RE: Suntop Solar Farm Modification 1 (SSD-8696-MOD-1) Request for Additional Information

We write in response to your letter dated 2nd August 2019 requesting additional information with respect to the proposed Suntop Solar Farm modification application. Please find our responses detailed below.

FIGURE 1 SITE LAYOUT RELOCATED SUBSTATION AND ANCILLARY BUILDINGS

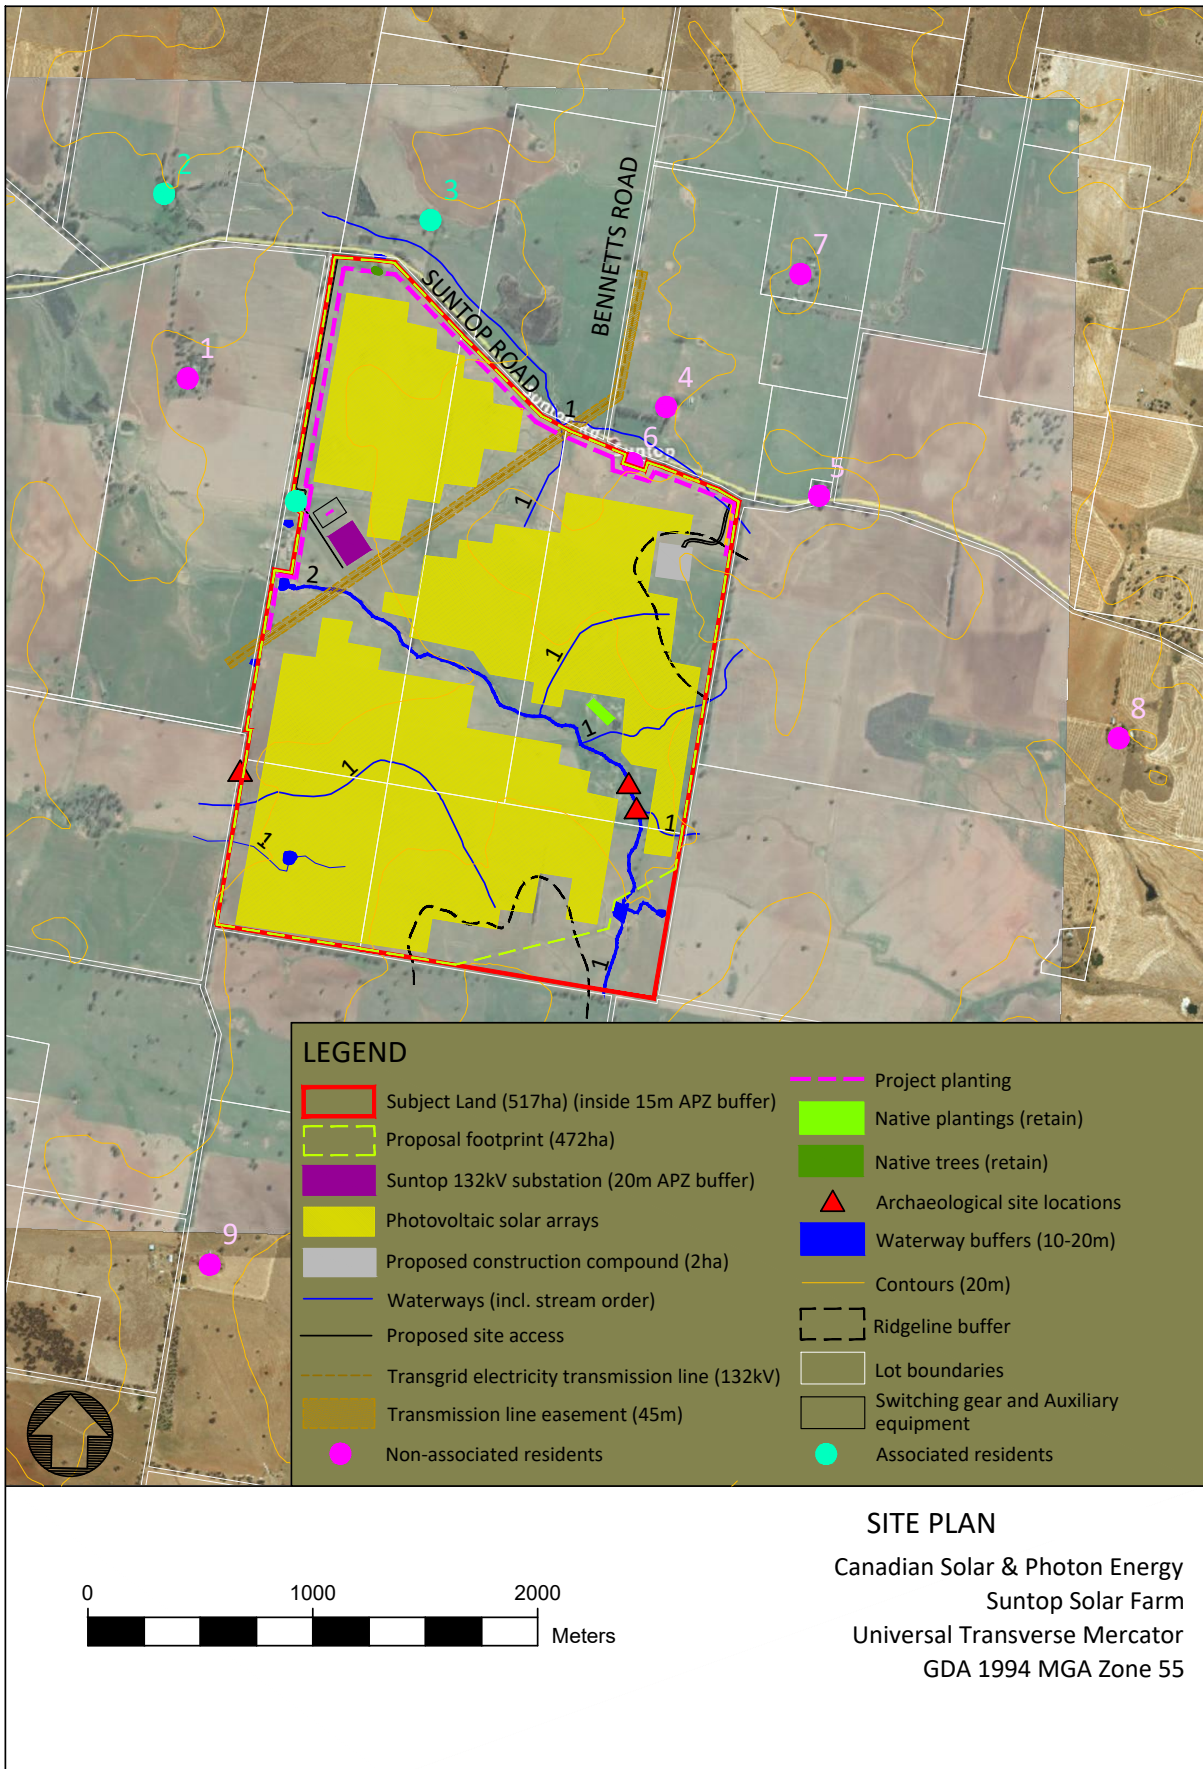
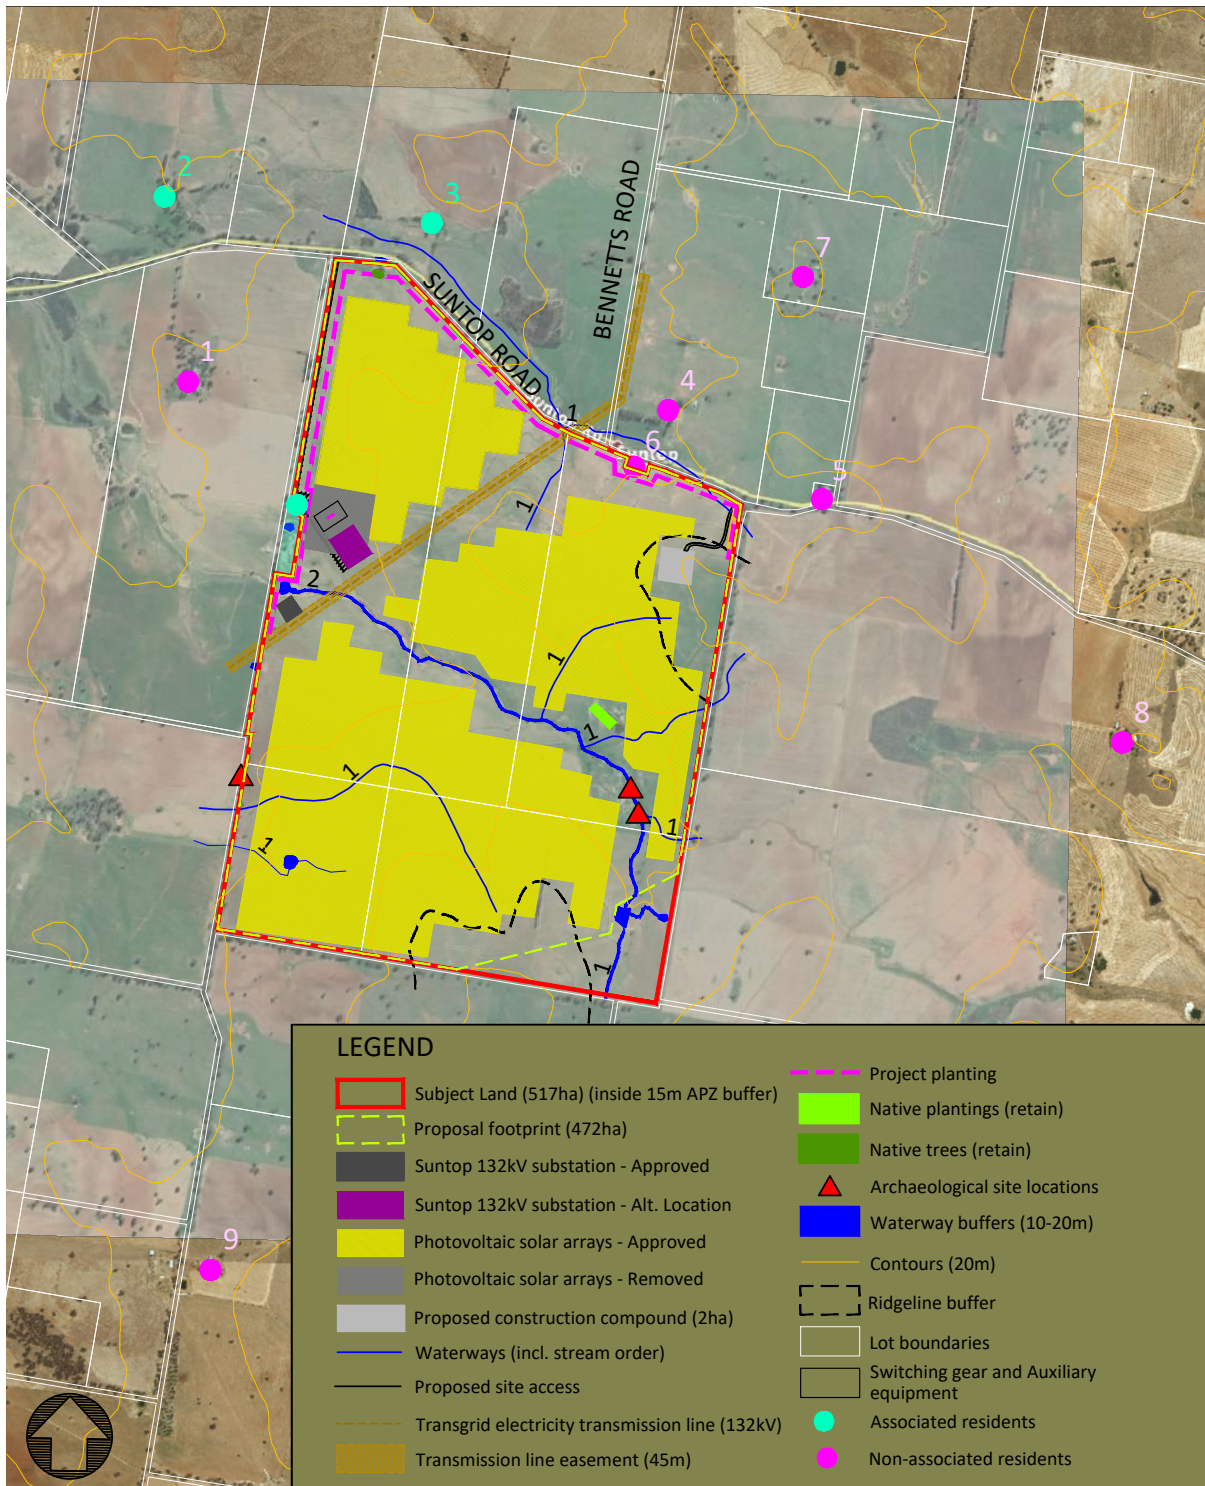
Request 1: Address TransGrid's request for a further relocation of the substation and clarify the impacts of a revised location.

In response to feedback from TransGrid, the substation and switchgear/auxiliary building areas have been moved approximately 50 metres southeast from their position shown in the submitted Modification Plans. The purpose of this further relocation of the substation is to ensure TransGrid do not require the creation of a further powerline easement between the substation and the existing 132kV powerline easement. The change requested by TransGrid is shown in Figure 1 and outcome from this change is shown in Figure 2 below.

The resultant layout from making the requested change by TransGrid is shown in Figure 2 below for reference. The setback between the powerline easement and the substation area boundary has been removed. The arrangement of the substation and the switching gear/auxiliary building areas remain unchanged.

The updated plans attached with this letter have been submitted to TransGrid for review and comment. TransGrid have subsequently advised via email that the changes in the updated plans meet their requirements. A copy of this email is attached to this response for reference.
